**GLEBE ISLAND EXPO (SSD 5589 – 2012)
ADDENDUM TO SUBMISSIONS REPORT**

Further to our Submissions Report dated 18 February 2013 and subsequent meeting on 19 February 2013, we wish to make the following amendments to the proposed development.

CAR PARK A
SCALE 1:1000

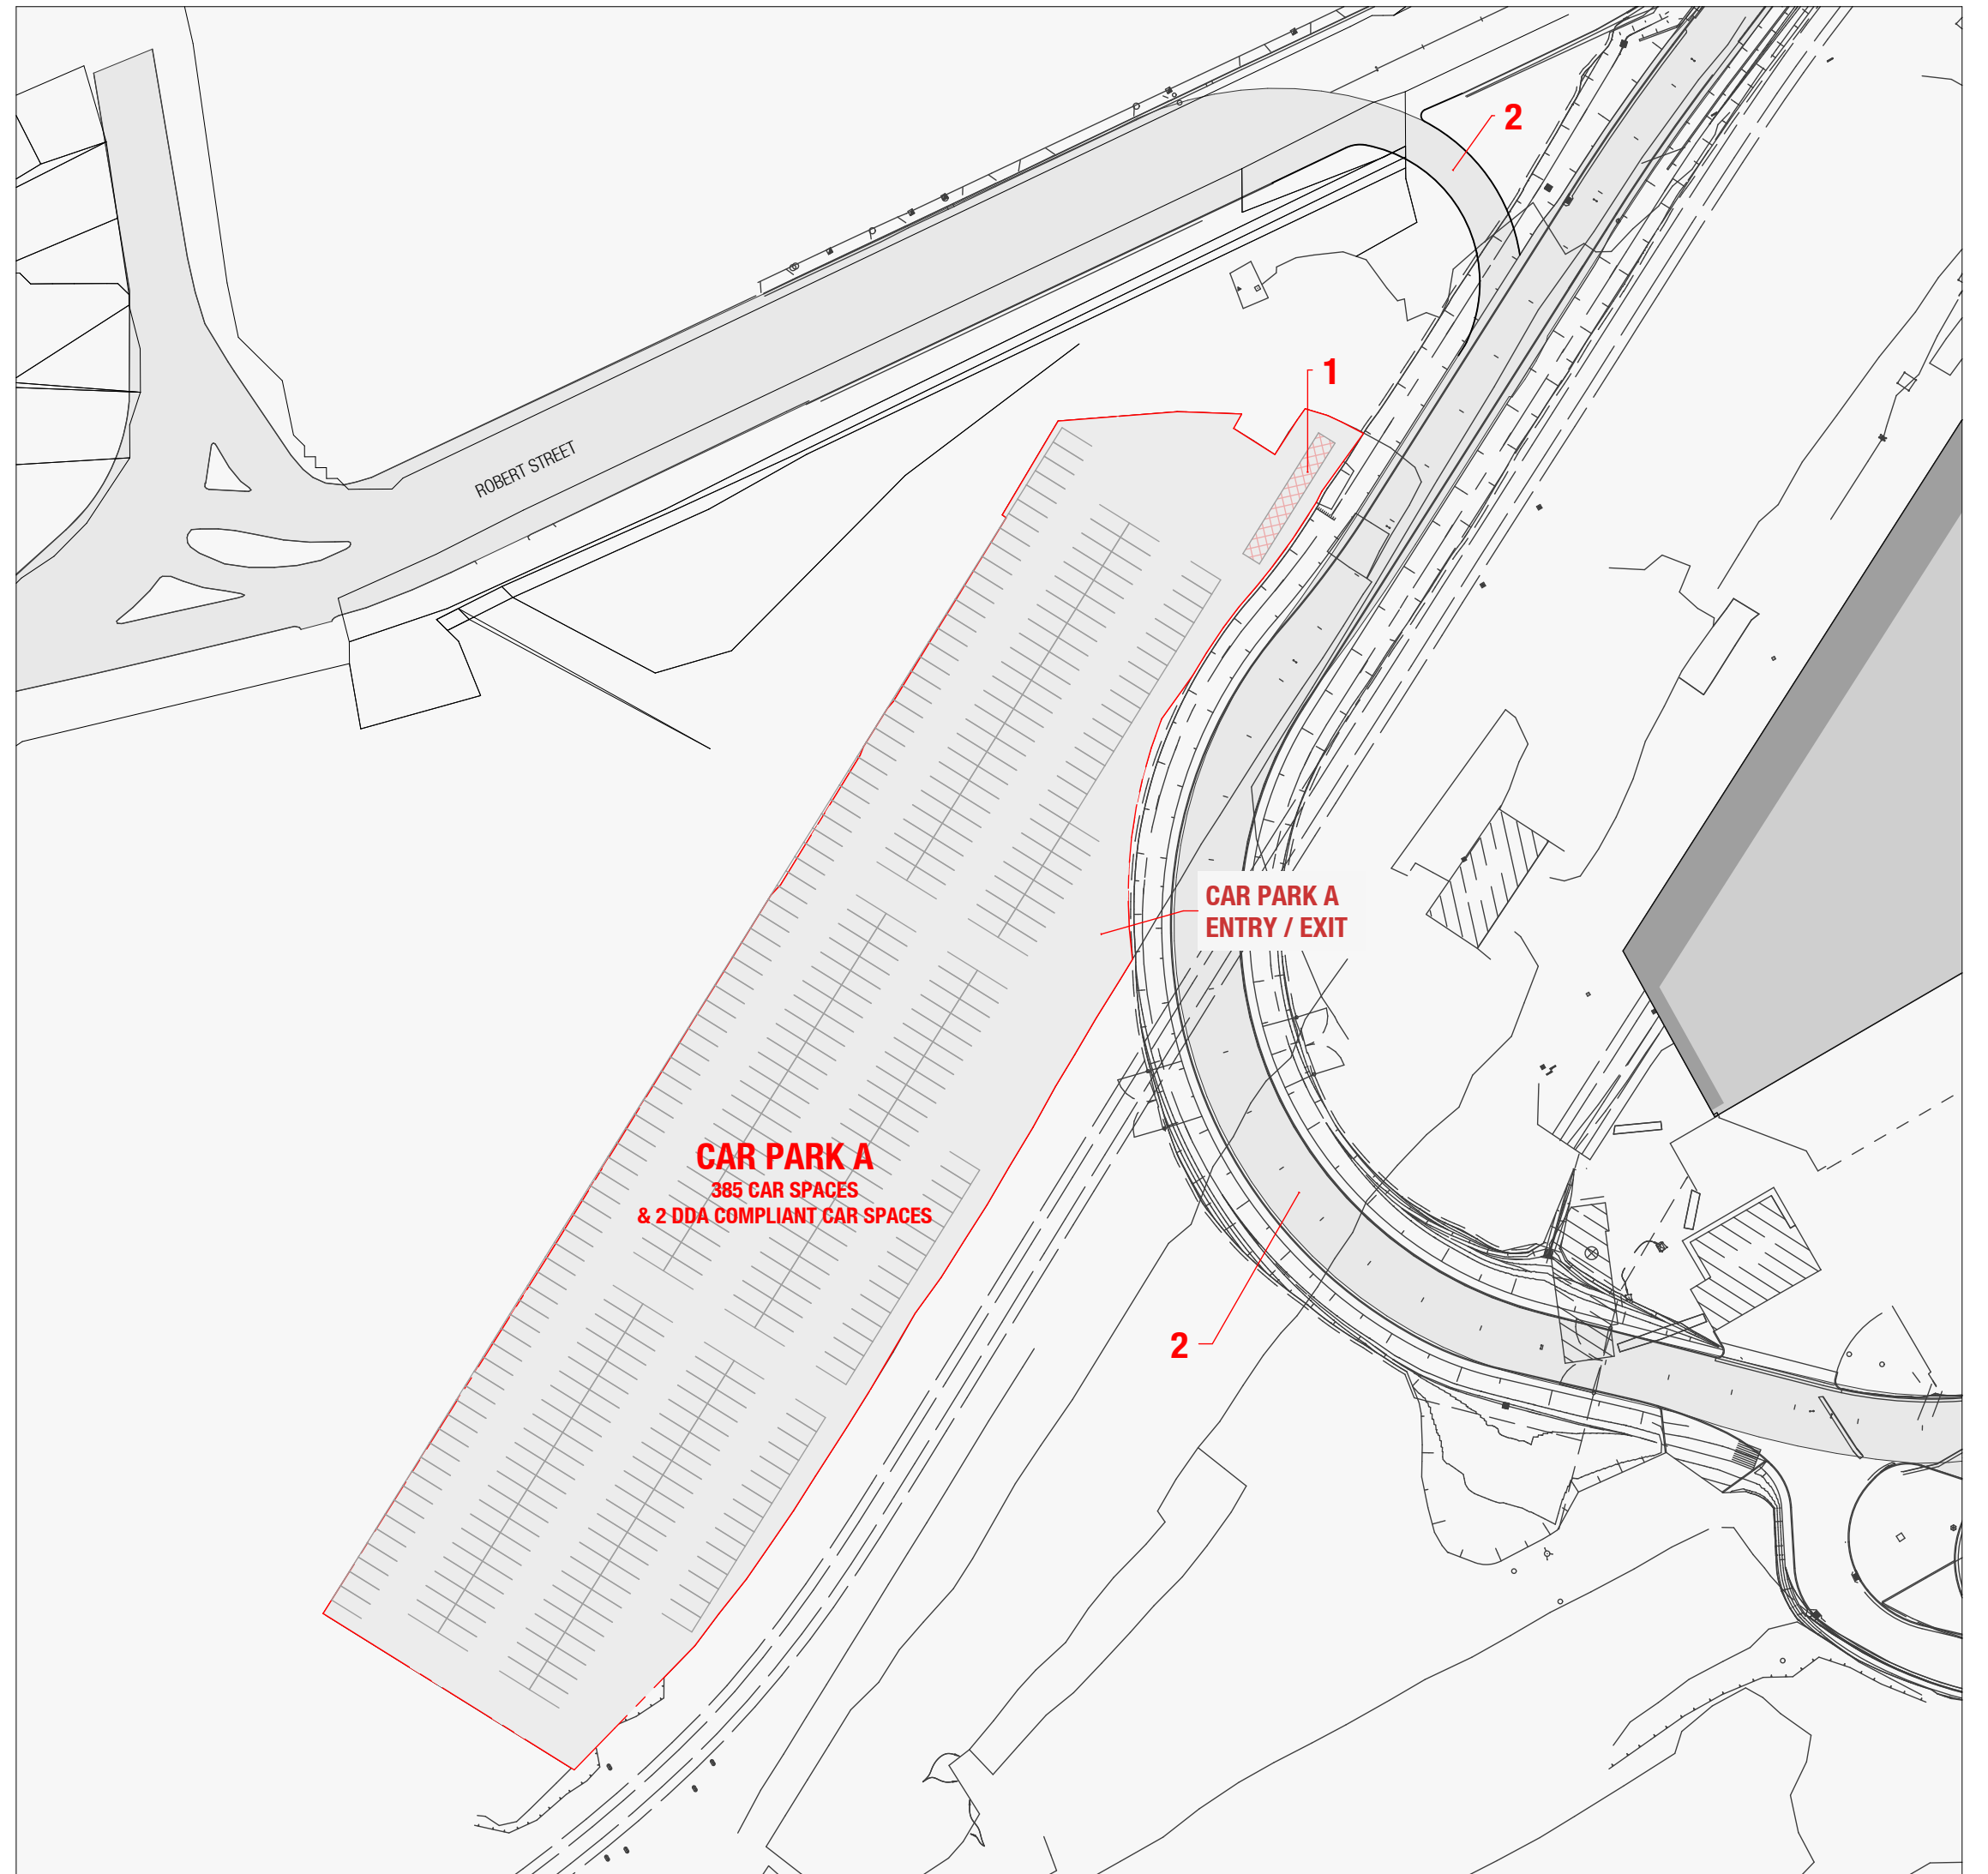
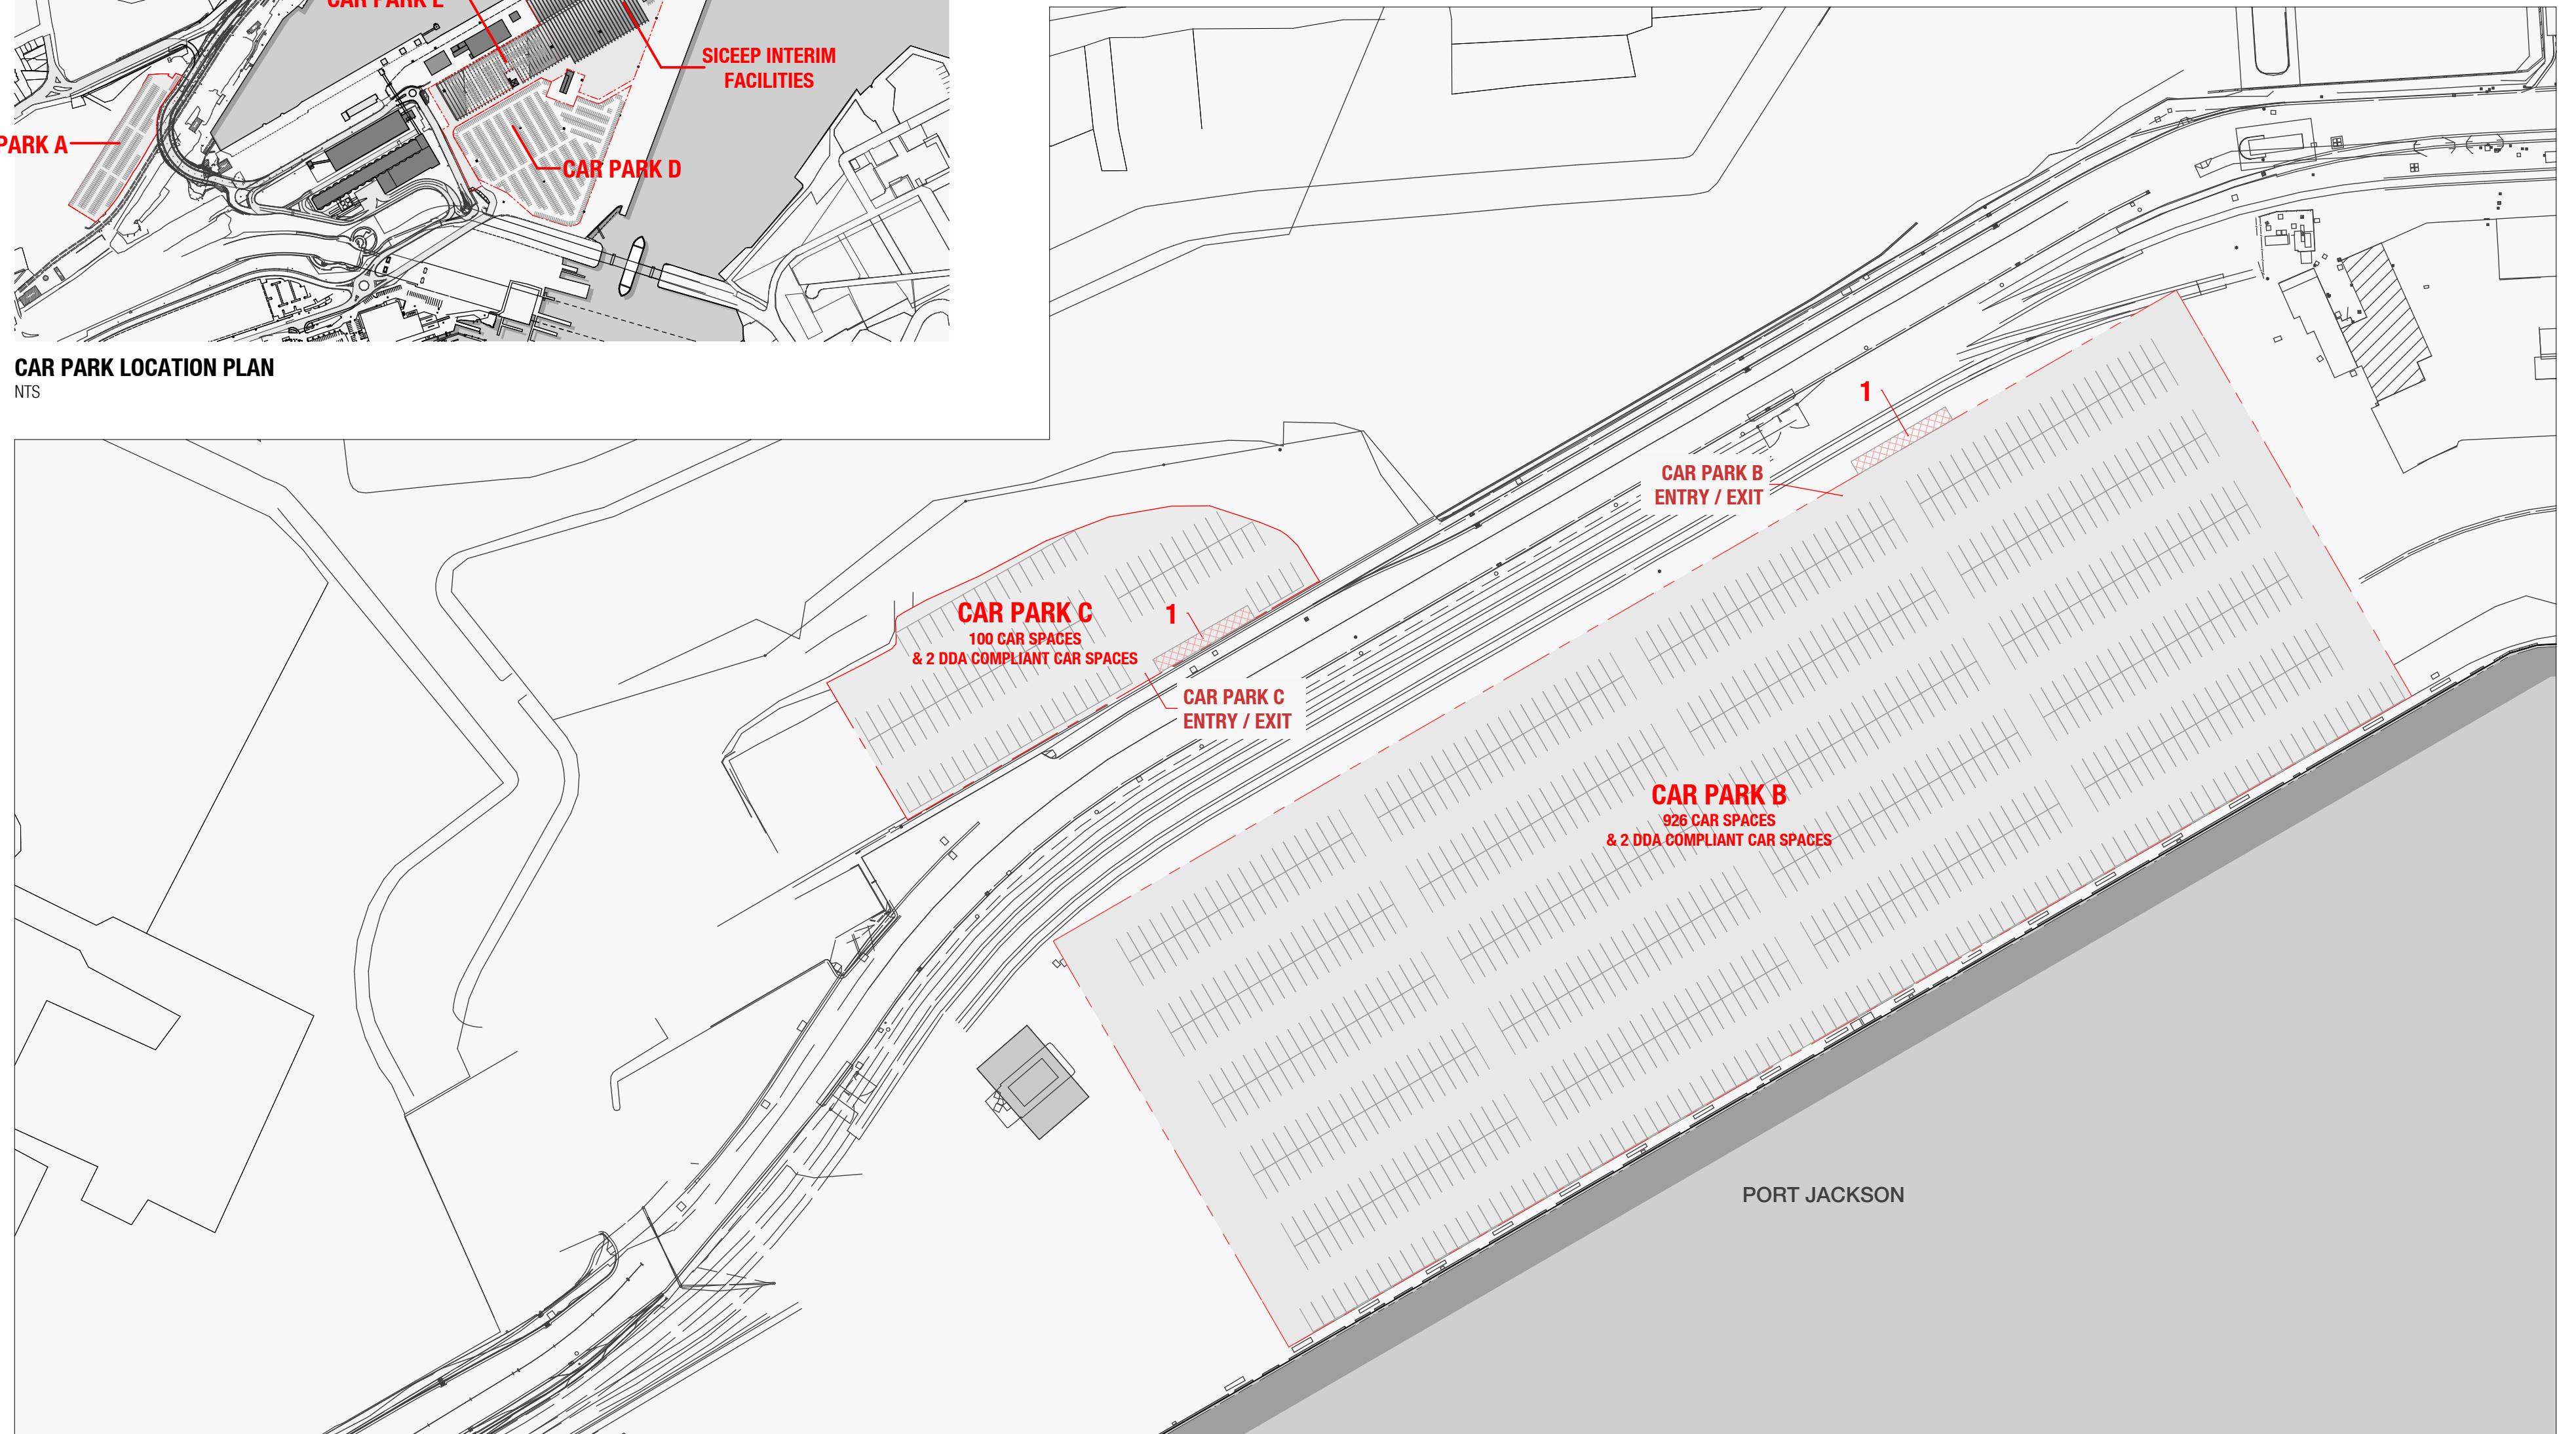
Development consent is sought for 1,000 vehicles. A total of 1,000 car parks will be provided within Sydney Ports' precinct by utilising the following locations:

- Hardstand area at the front of the White Bay Power Station (Car Park A, up to 385 spaces);
- Land to the north of White Bay Wharf No. 4 (known as the long term car park for the White Bay Cruise Passenger Terminal) (Car Park C up to 100 spaces); and
- Within Exhibition Hall 01 when not utilised for an exhibition event (Car Park E, up to 268 car spaces).

Additional overflow car parks in the following areas, the exact location depending on port requirements at the time:

- Additional Areas on Glebe Island (Car Park D, up to 1,038 car spaces) and / or
- Areas at White Bay (Car Park B, up to 446 spaces).

The proposed areas of car parking are shown on Architectural Drawing Nos. A2700-A2702 (Revision C) prepared by Woods Bagot and included at Appendix A.

The total number of car spaces to be used in any event will be no more than 1,000 car spaces. The location of those 1,000 car spaces will be determined on an event by event basis and documented in the Travel Management Plan to be prepared for each event.
